Ecology response

From: Jonathan Best <Jonathan.Best@arun.gov.uk>
Sent: 27 January 2025 10:41
To: Planning.Responses <Planning.Responses@arun.gov.uk>
Cc: Harry Chalk <Harry.Chalk@arun.gov.uk>
Subject: A/2/25/PL

110 Downs Way East Preston BN16 1AF.

PROPOSED LANDSCAPING 1:150

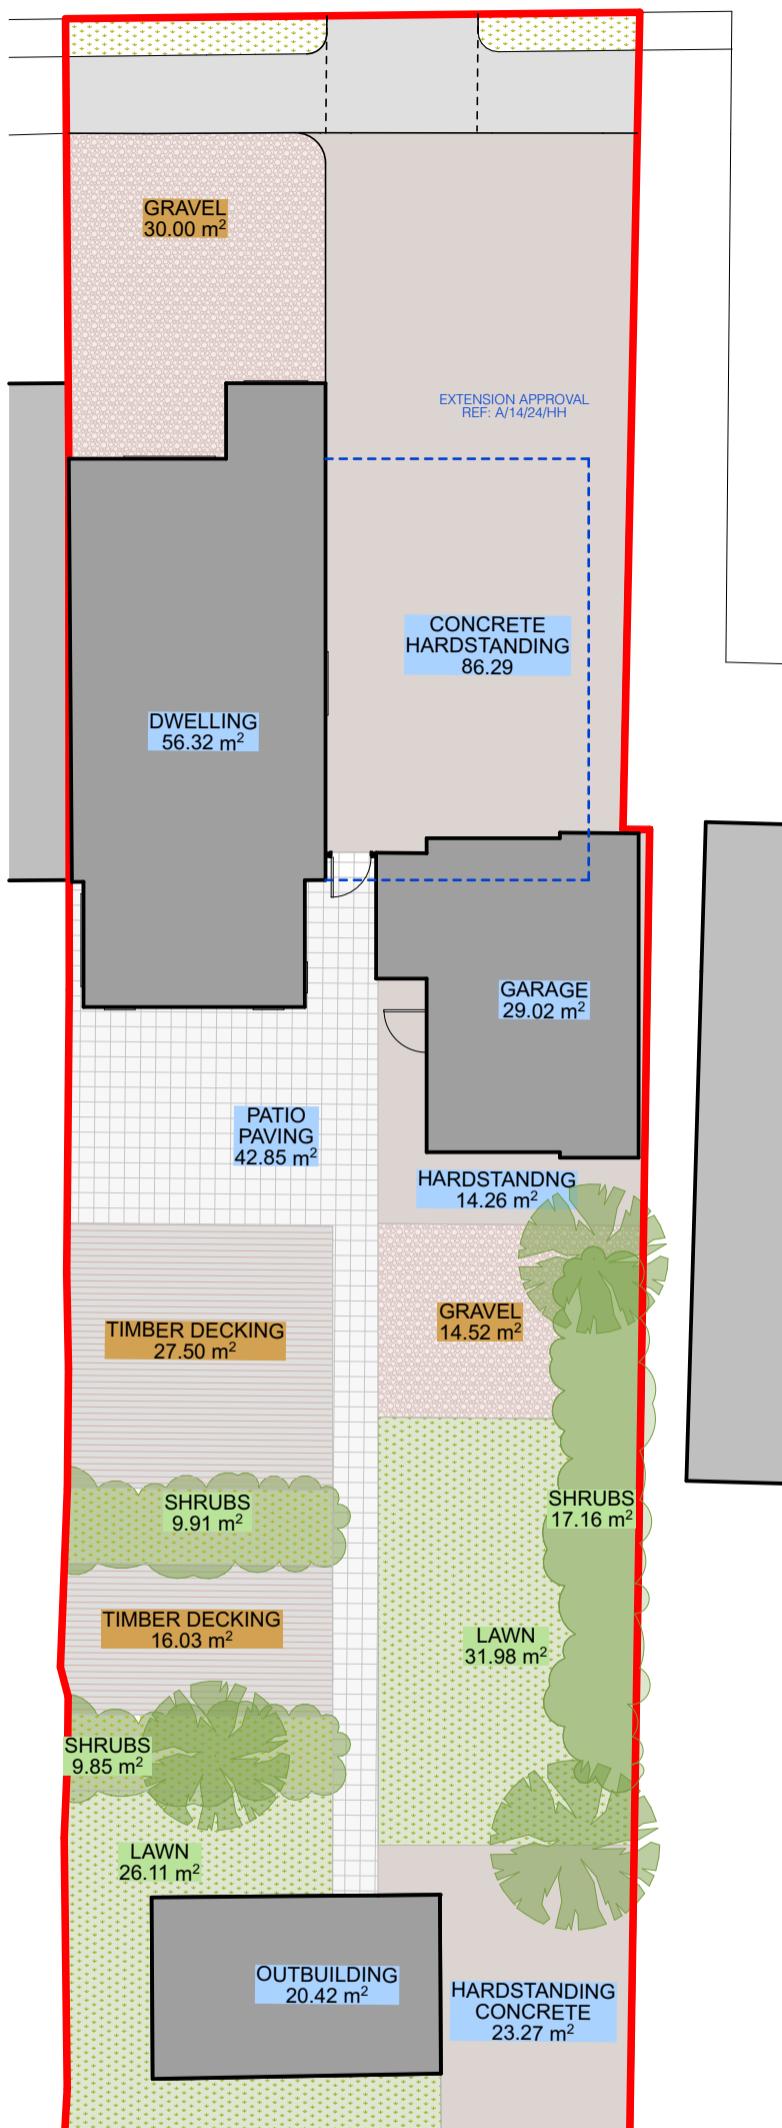
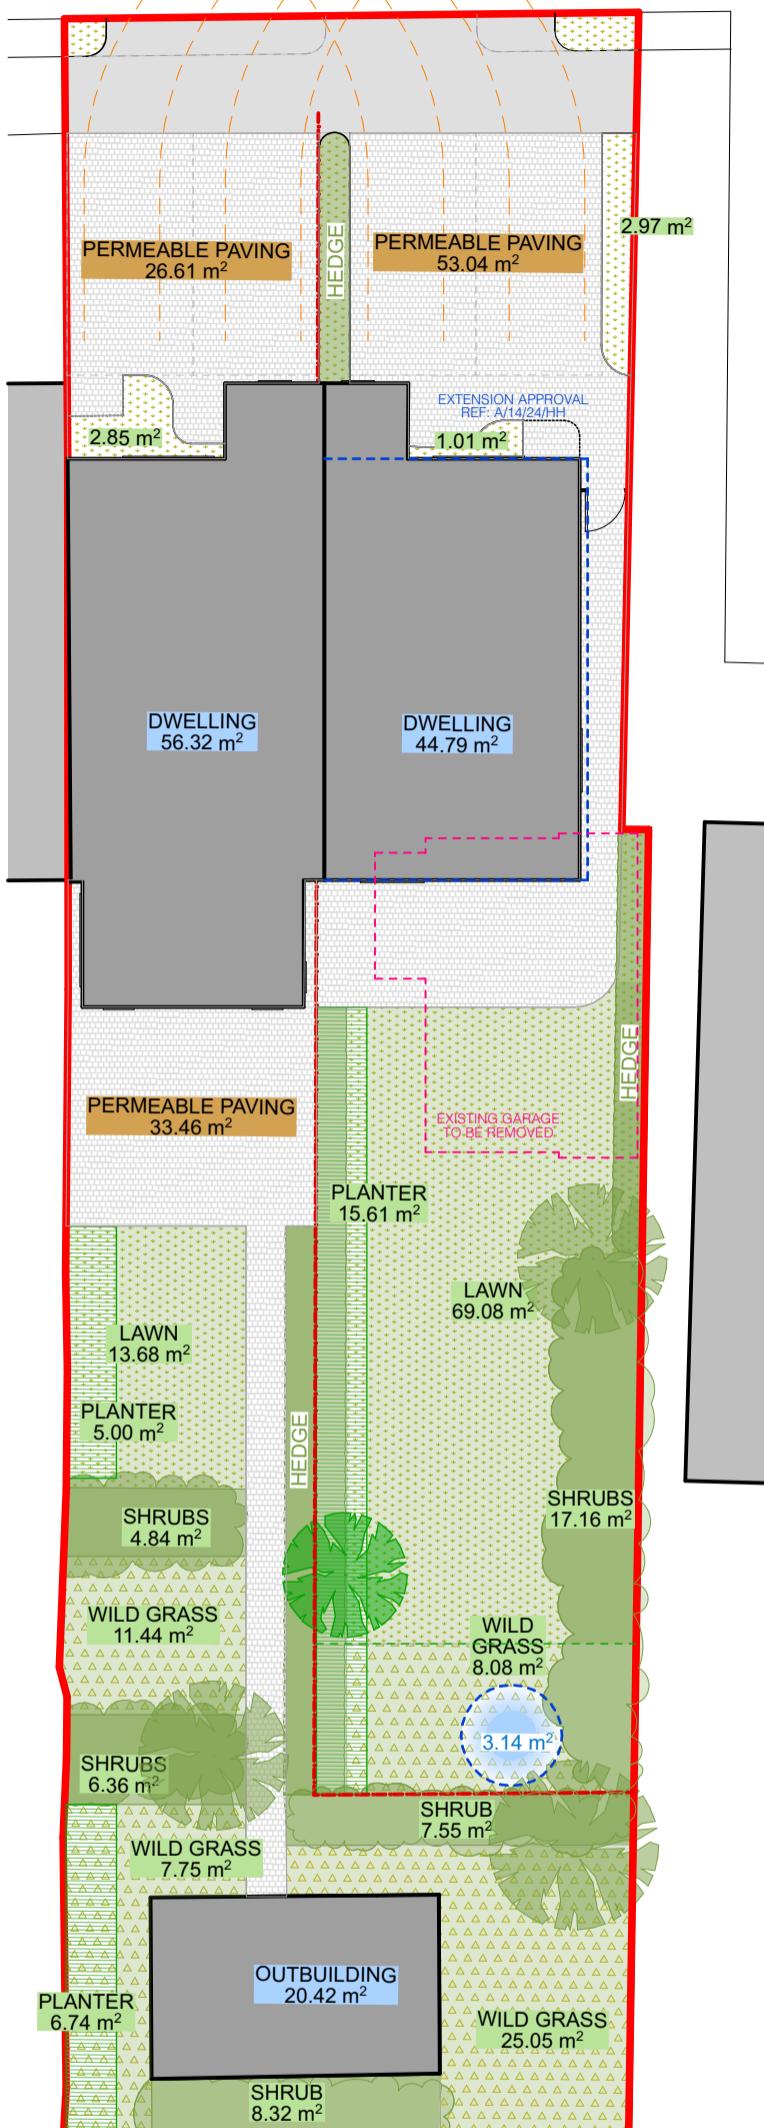
The metric also has included gains in linear habitat. The hedgerows should be native and are welcomed. However, hedgerows in private gardens cannot be counted as separate features. This does not impact the final result as this has been met through provision of enlarged private garden and ground level planters.
